From: Karen Garner
Sent: 25 February 2020 14:09
To: Planning Scanning
Subject: FW: EOT Request AL/106/19/DOC - Comments from Environmental Health for more information

From: Fiona Fitzgerald [REDACTED]
Sent: 20 January 2020 12:34
To: Planning.Responses [REDACTED]
Cc: Karen Garner [REDACTED]
Subject: AL/106/19/DOC

REV. No.	DATE	DESCRIPTION	INITIALS
Client			
Project	Westergate & Eastergate		
Title	External Works Layout Sheet 1	Scale 1:250@A0 Checked AMc	Date Mar '18 Drawn KT
Drawing No.	5655:40	Rev	H

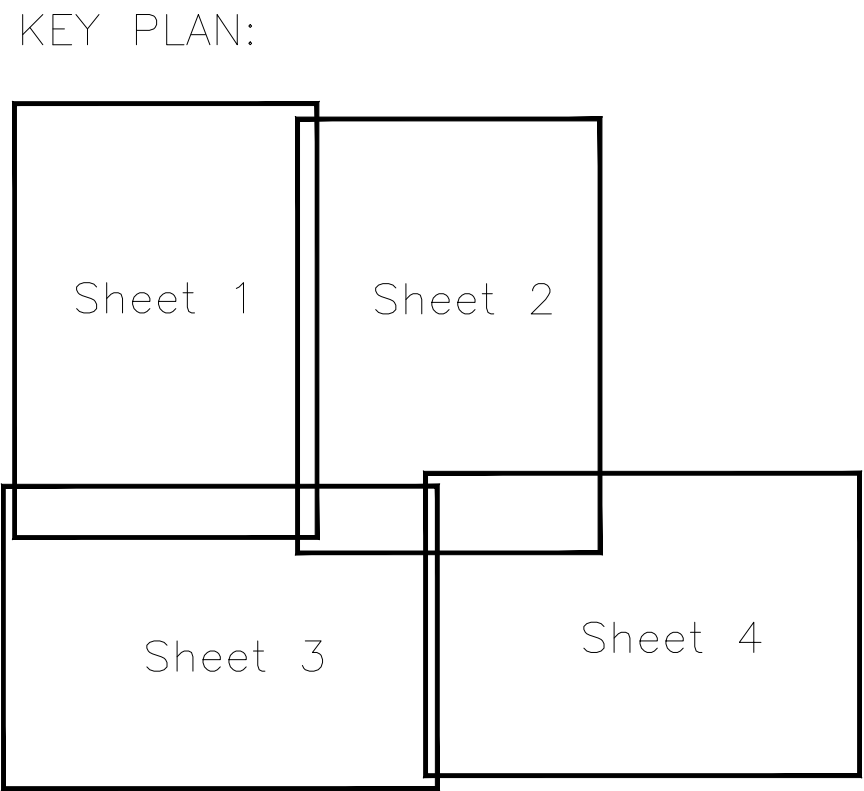
Lighting – condition 7, some lighting was shown on one of the engineers maps, but I couldn't find any confirmation within the application that the lighting scheme proposed complies with the Institute of Lighting Professionals Guidance Zone E2. Please could this be confirmed.

DRG. No.:		20627/001/CMP	REV.: C

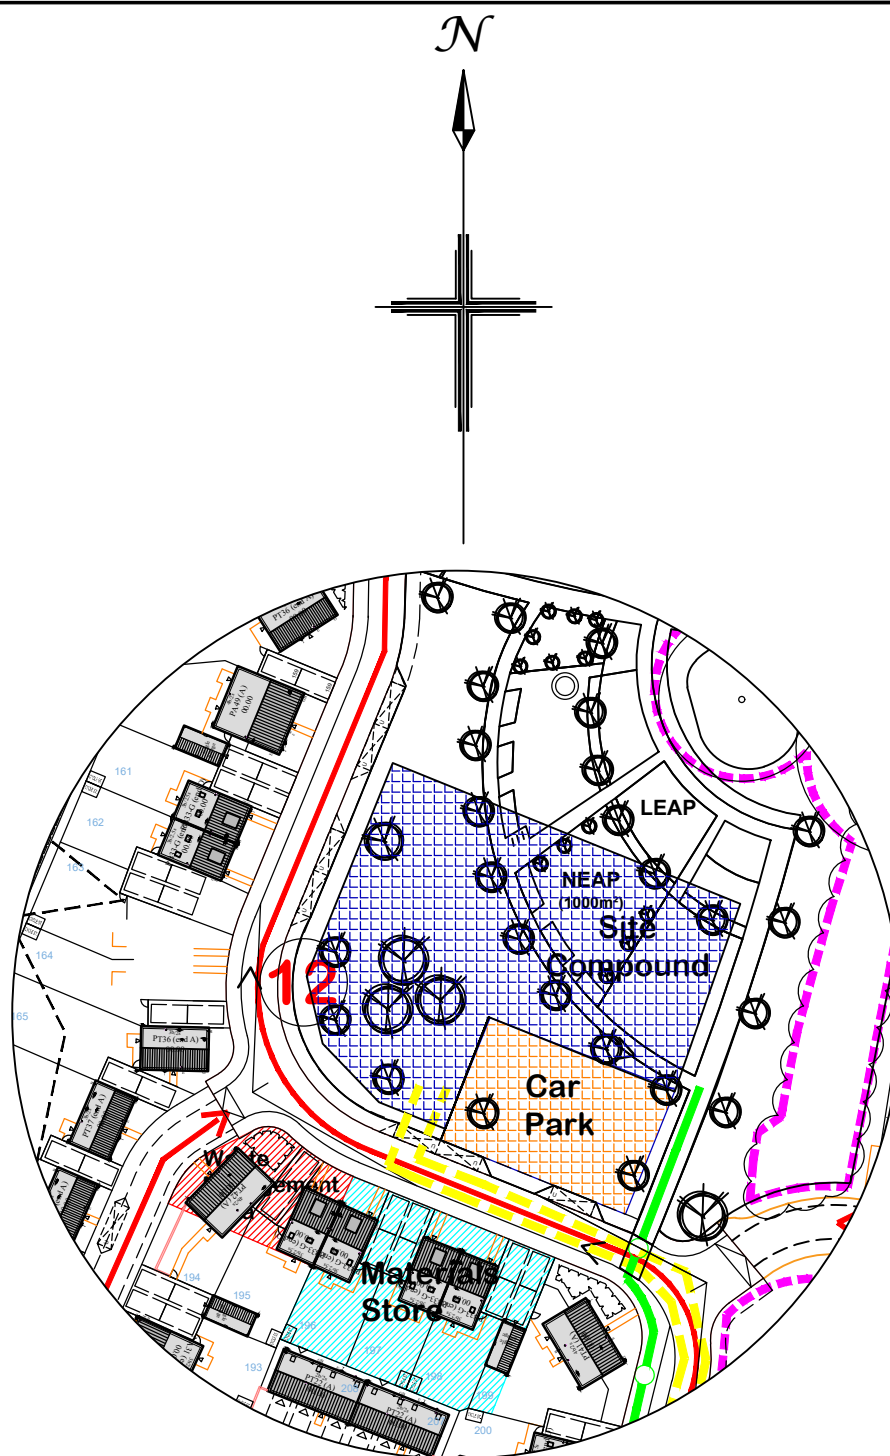
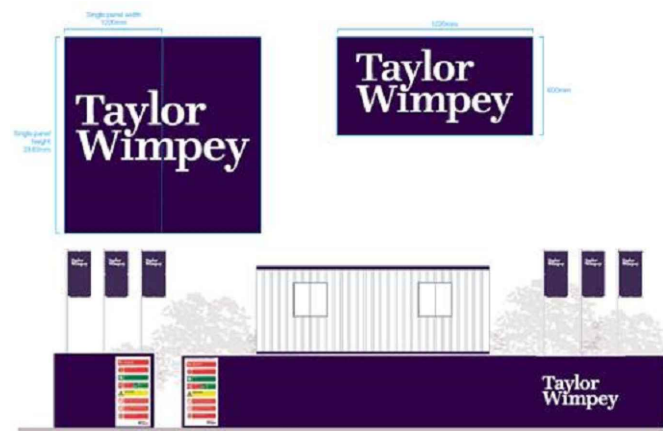
With regard to condition 10 (CMP), please could the applicant expand on two points. Site Lighting – what measures will be taken in the event of a complaint. Secondly, noise prevention – please could this section be revised in much

more detail. Given the history of noise complaints we have already had with this site, I am not satisfied that the information provided in this section is sufficient.

Please find attached the updated CMP plan, it has been amended to capture the comments denoted below.
The lighting information was sent to you under separate cover yesterday.
